**IN THE MATTER OF AN APPLICATION BY NATIONAL GRID  
ELECTRICITY TRANSMISSION FOR AN ORDER GRANTING  
DEVELOPMENT CONSENT FOR THE NORWICH TO TILBURY PROJECT**

**PINS REF: EN020027**

**Ardleigh Parish Council**

**Viewpoints and Visualisations in the  
Ardleigh and Little Bromley area**

Drawing file: published-documents / EN020027-002384-8.9.1 Norwich-Tilbury OHL LVIA-7.12 Visualisations - HE - HE24_REVB.pdf

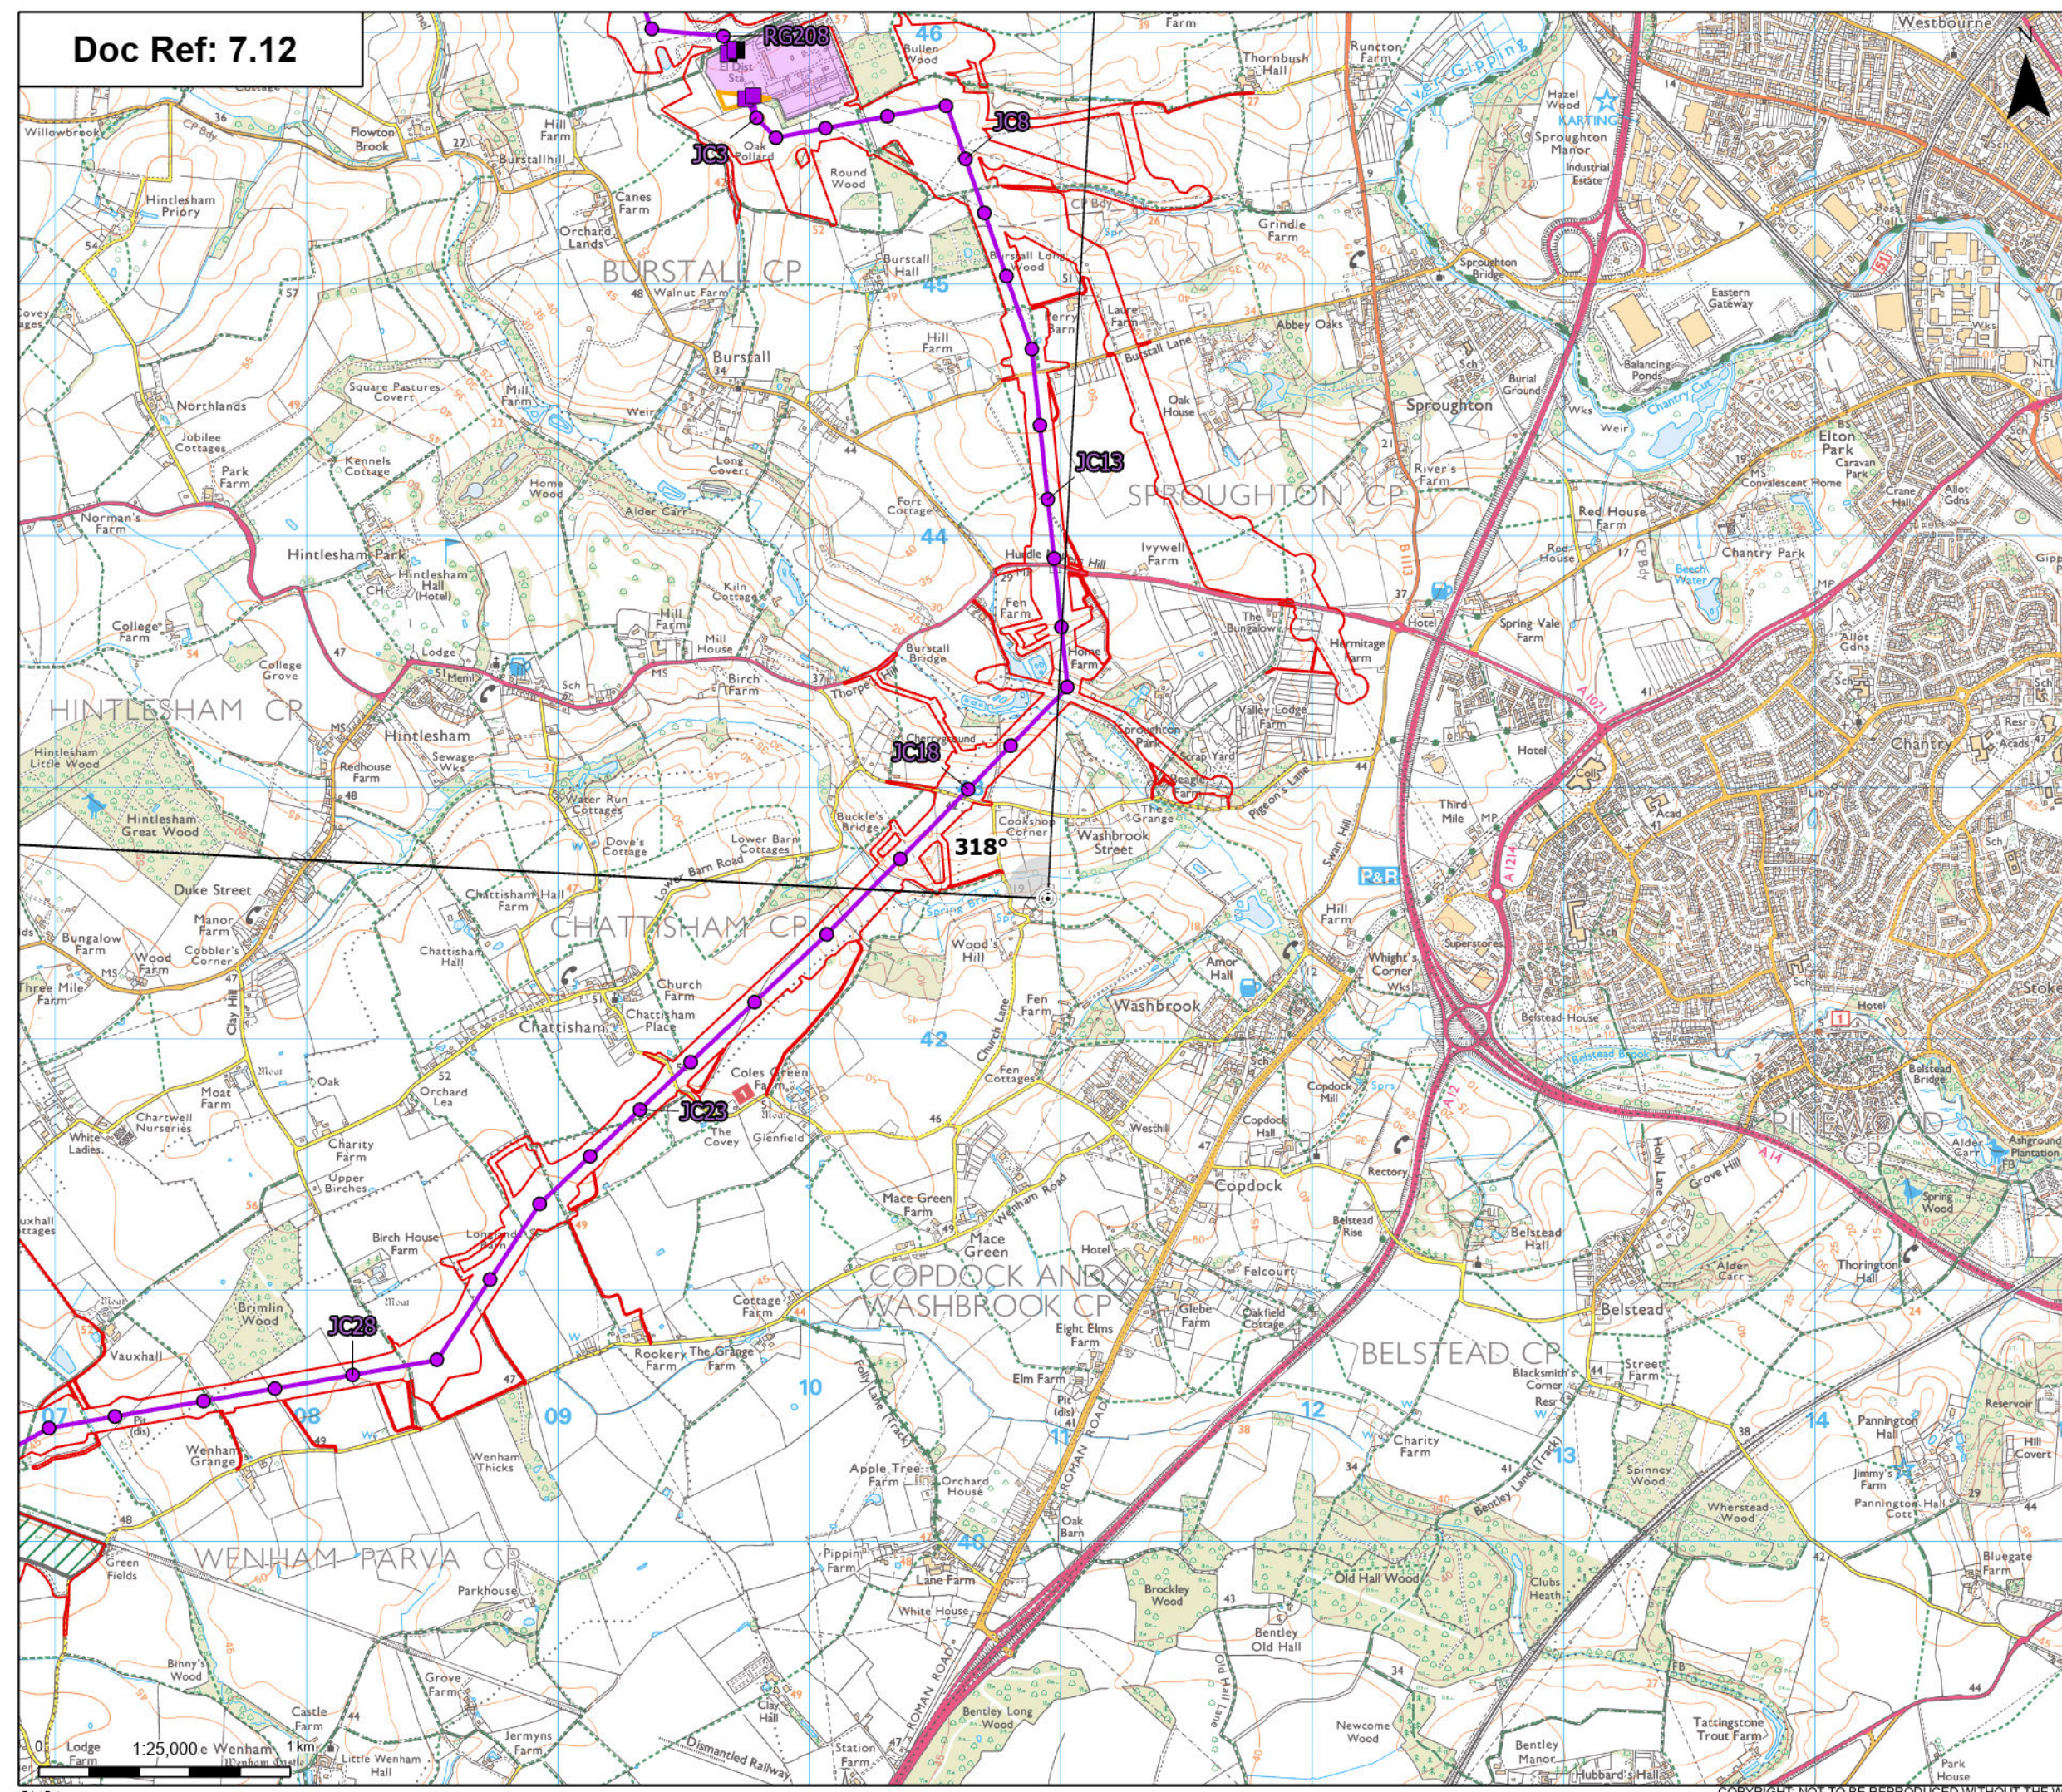
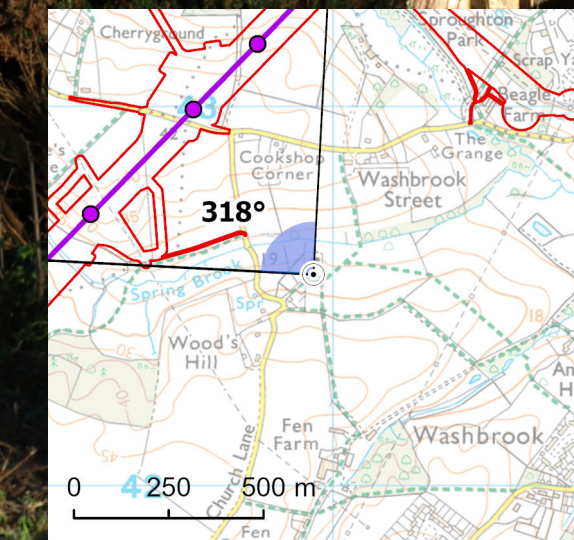
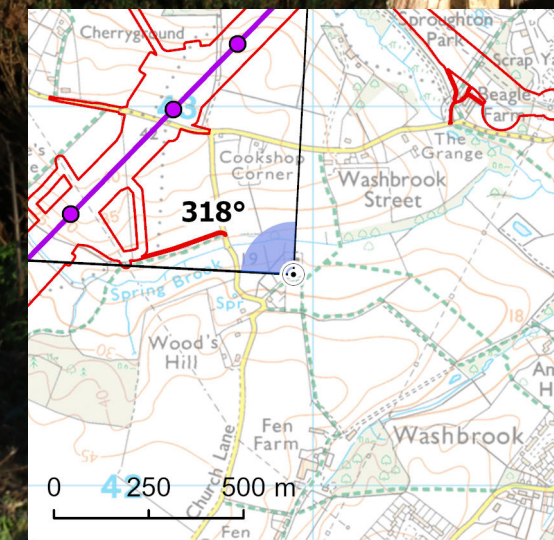
The Applicant's photomontages HE25b, HE25c, HE25d and HE25e from viewpoint HE25 are provided in Sections 2.1.1. and 2.1.2. of Appendix A.
